Ribble Valley Borough Council
Planning Section
Council Offices
Church Walk
Clitheroe
BB7 2RA

App No 3/2024/0797
Proposal Proposed demolition of existing holiday let chalet and replacement with one single storey two-bedroom holiday-let.
Location Hazelmere Longridge Road Hurst Green BB7 9QP

The submitted documents have been reviewed and the following comments are made.

DRAWING TITLE:
Entrance Elevation

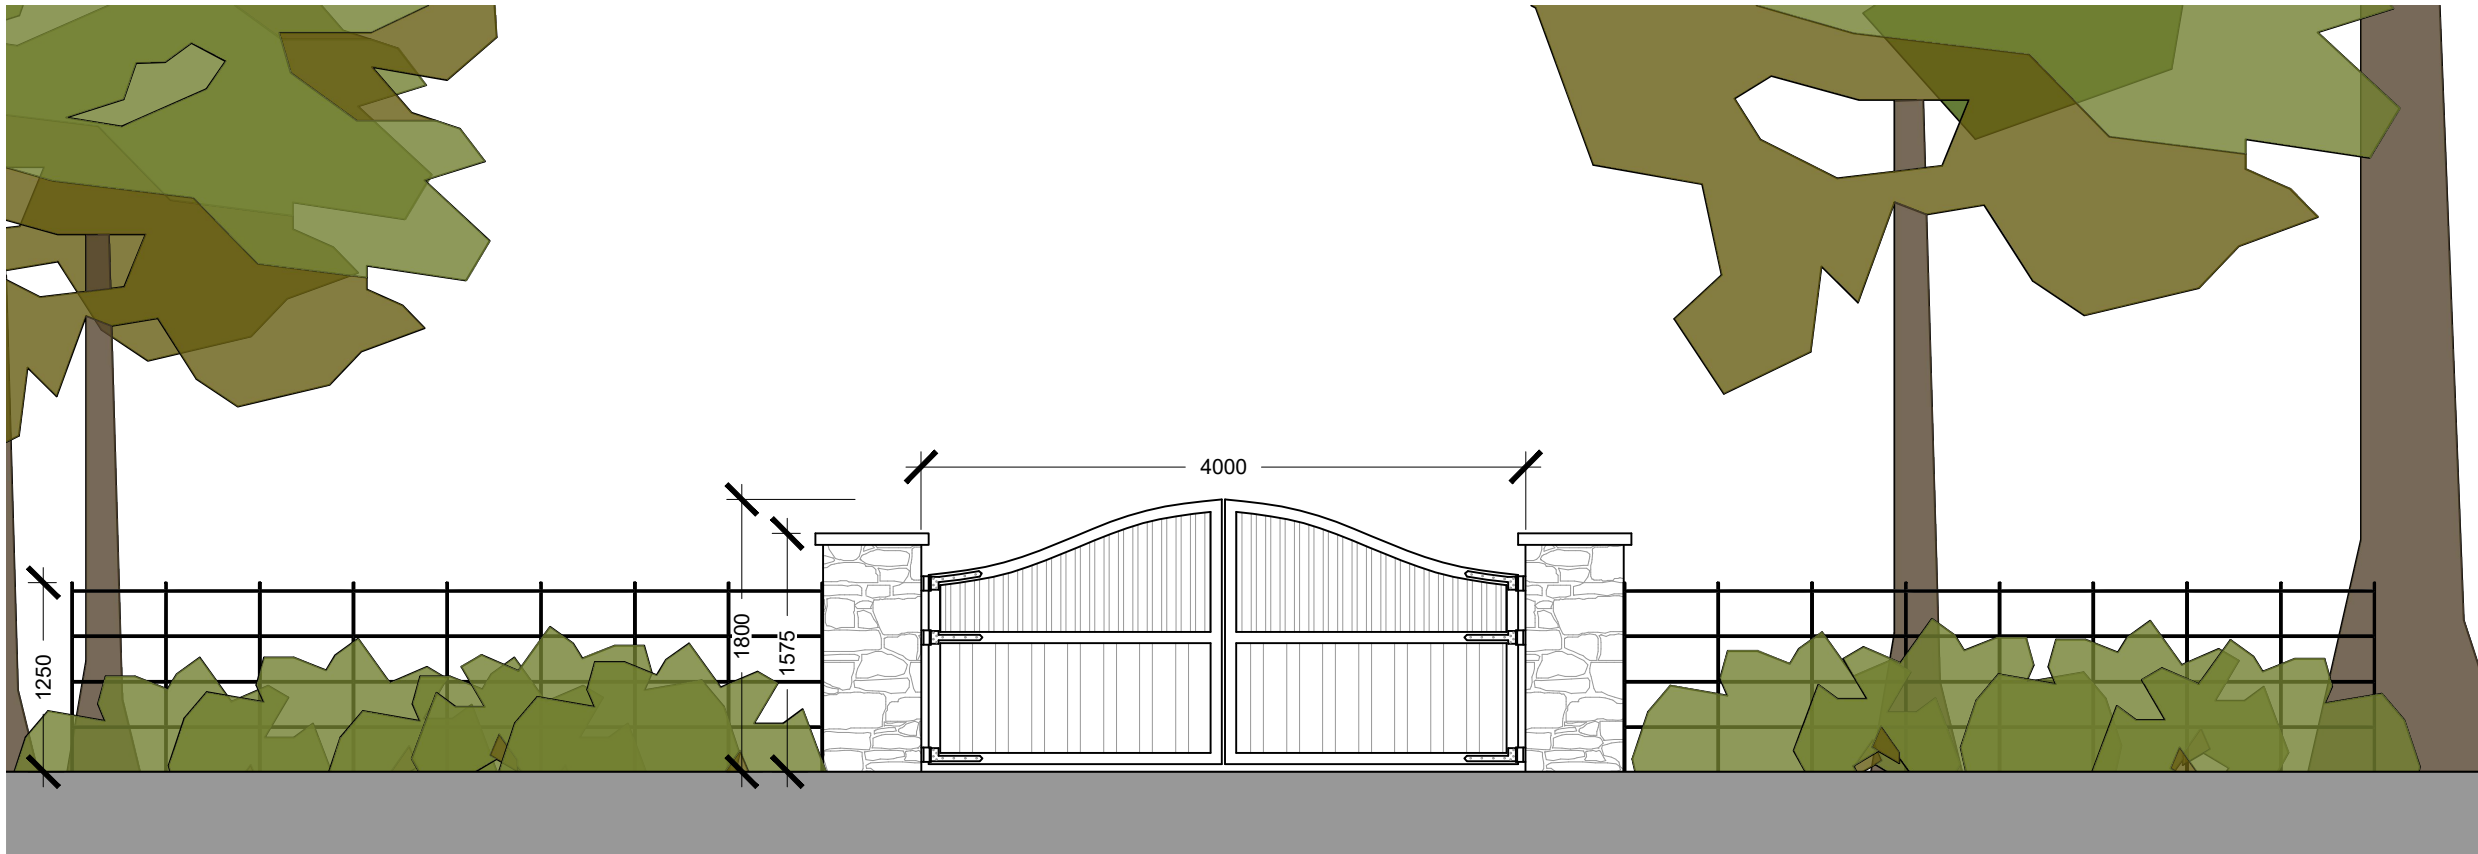
There is a proposal to realign and widen the site access which is considered necessary. The access is proposed at a width of 4m which is considered acceptable. The gates are set back by 5.6m and this is considered acceptable. The site access for at least the first 5m should be paved in a bound and porous material and the surface water should be collected and drained to a suitable outfall.
